**Re: Home 2 Suites – 3021 University Blvd. SE  
Erosion and Sediment Control Plan  
Engineer's Stamp Date 11/6/2020 (M15E047)**

Based upon the information provided in your submittal received 9/29/2021, the above-referenced ESC Plan cannot be approved until after the following additional information is provided.

TEMPORARY EROSION AND SEDIMENT CONTROL PLAN

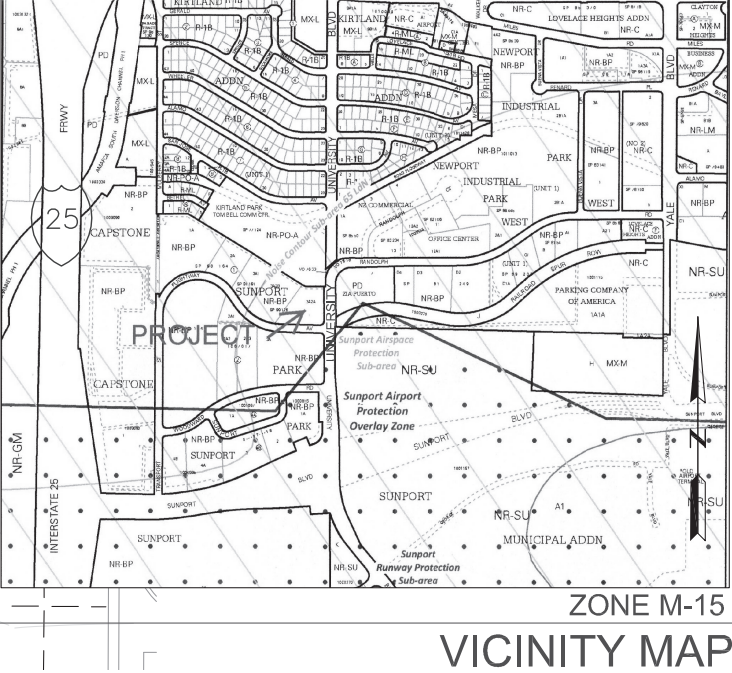
1. The ESC Plan can't be approved until after Hydrology approves the G&D Plan for each specific purpose, Site Plan, Grading, Building Permit, and Work Order. The only purpose Hydrology has approved so far is Site Plan. The existing and proposed grades must be shown on the ESC Plan, and they must agree with the Grading Plan approved by Hydrology (CGP7.2.4.b.ii);

2. The ESC Plan can't be approved for Grading or Work Order until the property owner's NOI has been reviewed and approved by City Stormwater Quality.
3. This site naturally drains into the private property to the west, and that must be changed as the first item of construction on the schedule and prior to any other land-disturbing activities. The drainage should be diverted to a sediment trap in the southwest corner of the site with a stable overflow spillway.

4. Add a legend to the plan and show the location of the limits of land disturbing activities including work in the adjacent right of way, the diversion, sediment trap, silt fence, inlet protection, waste container, concrete washout, porta potty, and NPDES posting (CGP7.2.4.b.i);
